File Ref. No: BFS15/1684 (9006)
TRIM Doc. No: D15/91854
Contact: Inspector Michael Gibson.
Email: bfs@fire.nsw.gov.au

Department of Planning & Environment
23-33 Bridge Street
SYDNEY NSW 2000

**Section 75W modification request to Orica Southlands Remediation and
Warehouse Project
(MP 06_0191 MOD 3)**

PROJECT
PORT BOTANY INDUSTRIAL ESTATE
McPHERSON STREET, BOTANY, NSW, 2019.
TITLE
SITE PLAN

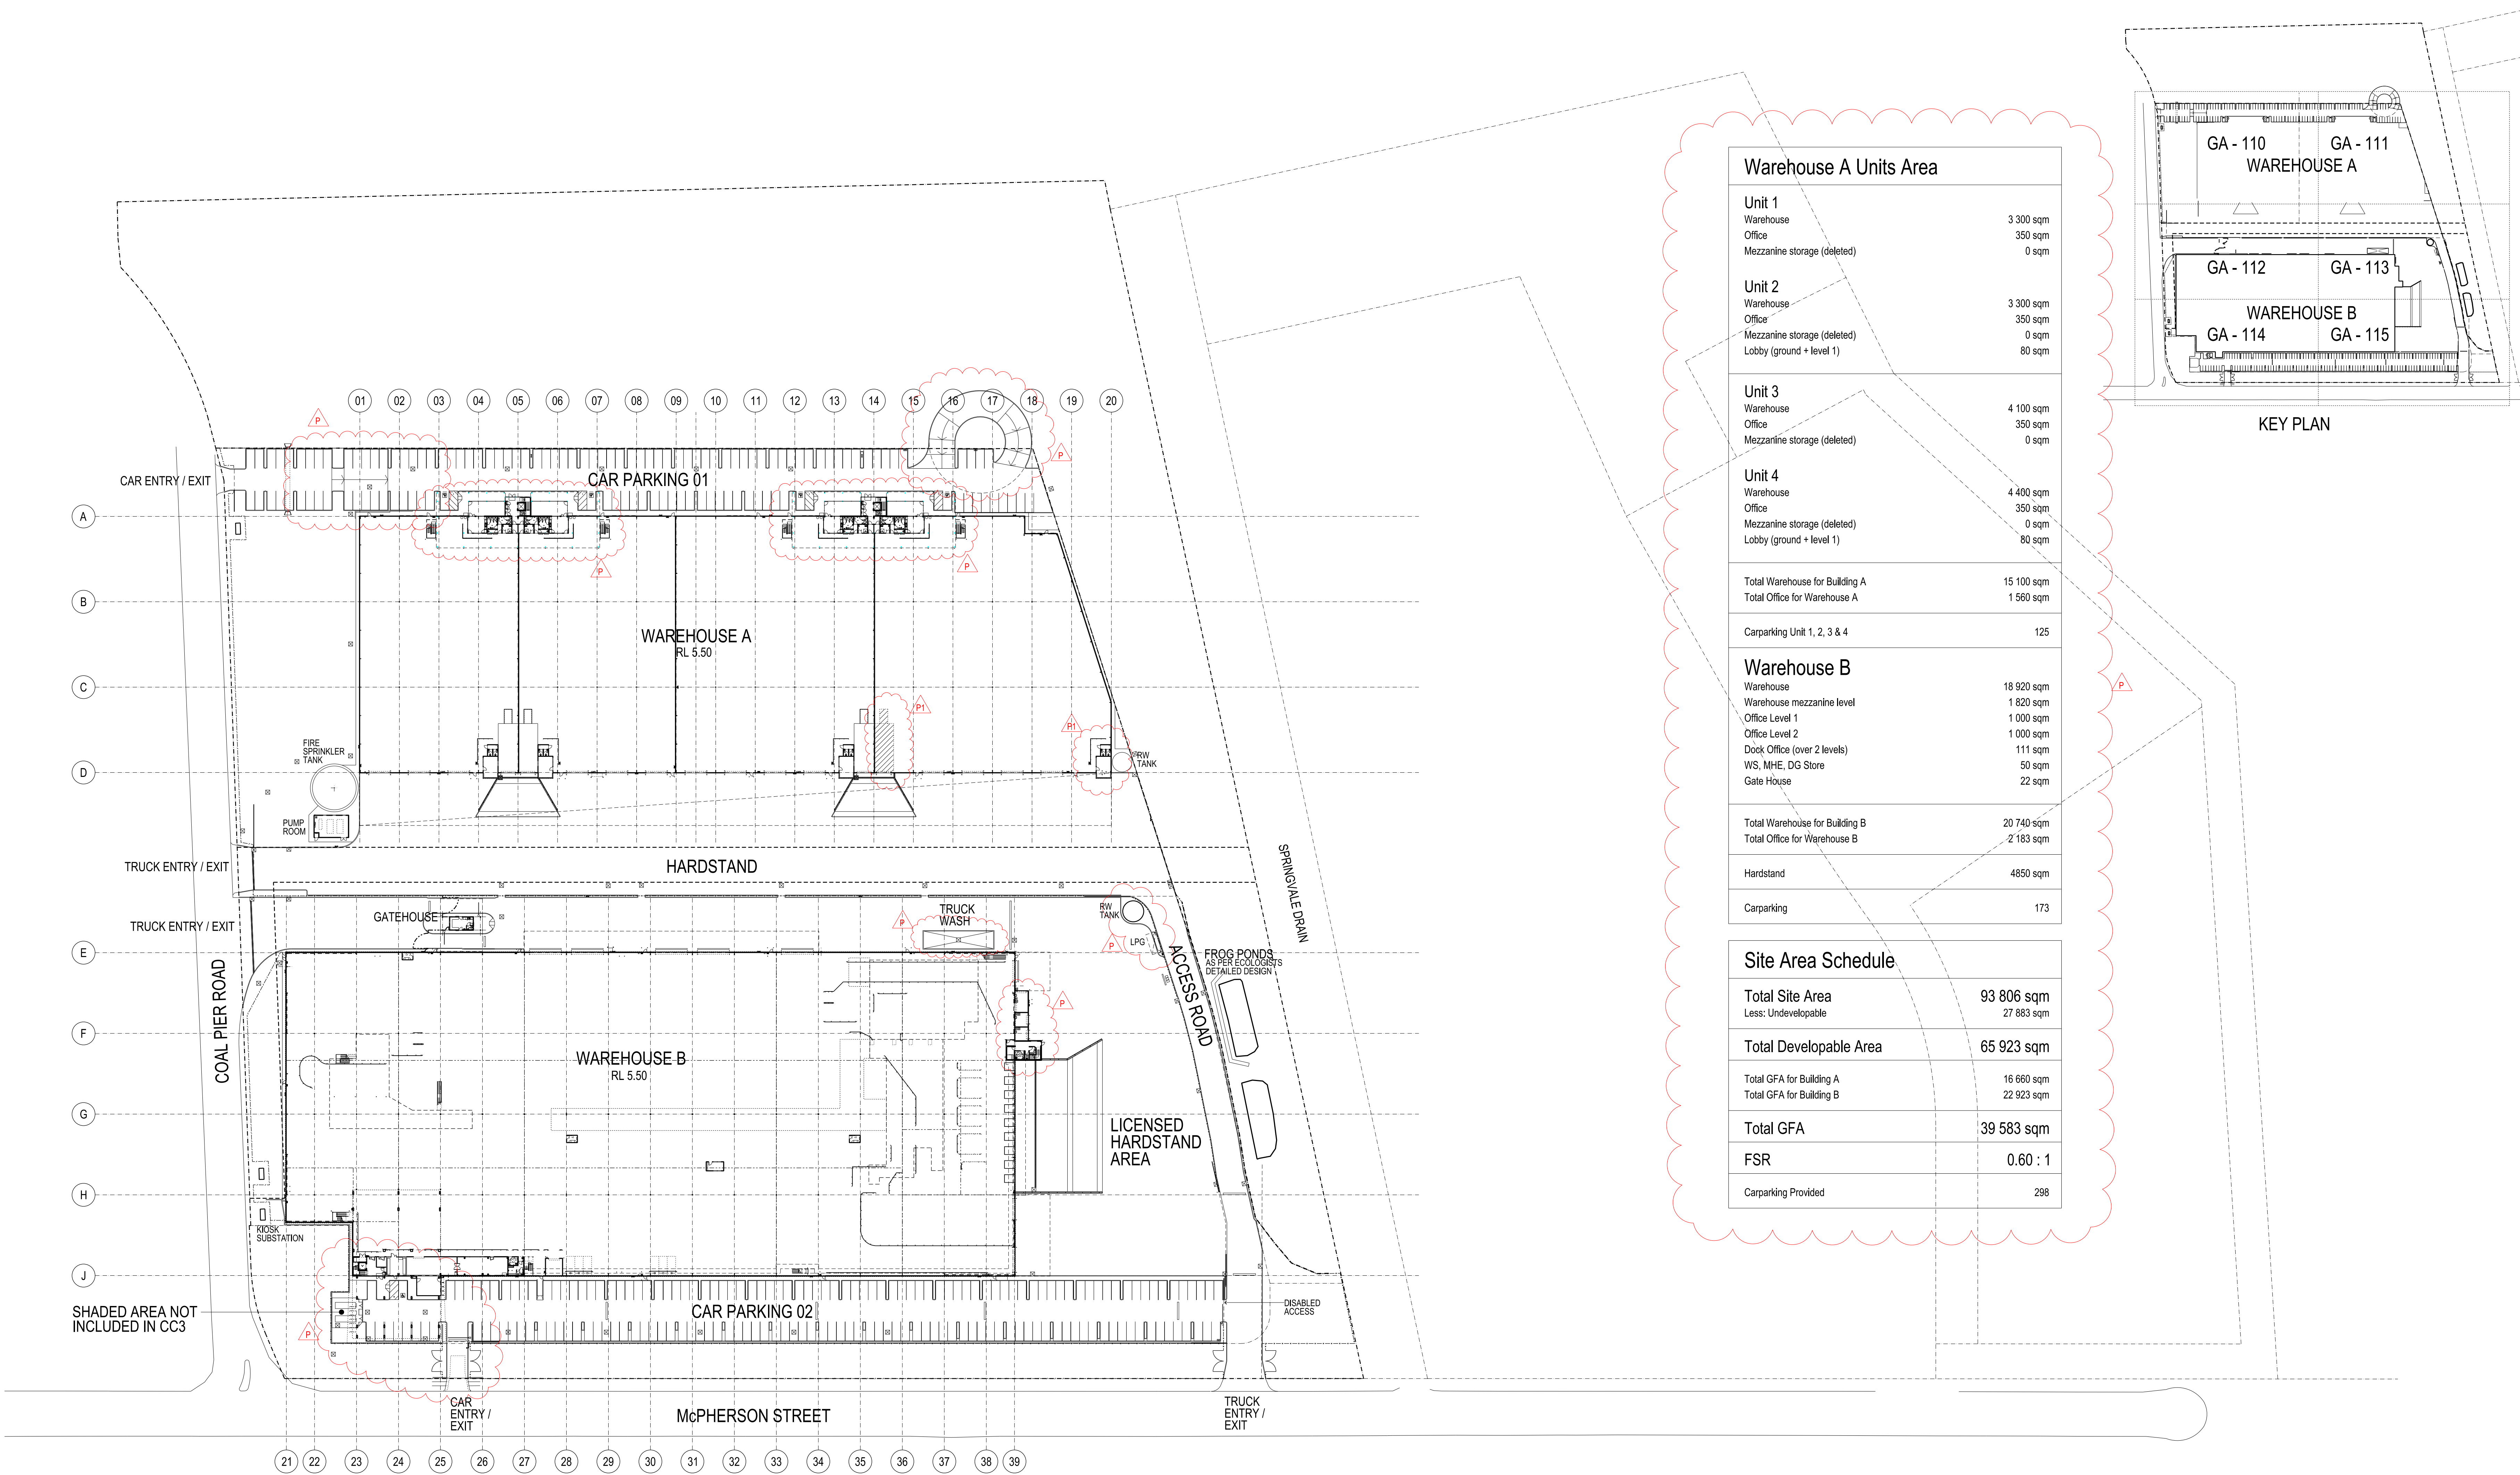
FRNSW recommends that carriageways not leading directly to an exit (i.e. dead ends) should be provided with a turnaround area, which prevents the need to perform multi point turns. The minimum turning radius of turnaround areas should be no less than 14.6m for aerial appliances as per Section 5.2 of FRNSW Policy No. 4 "Guidelines for Emergency Vehicle Access"
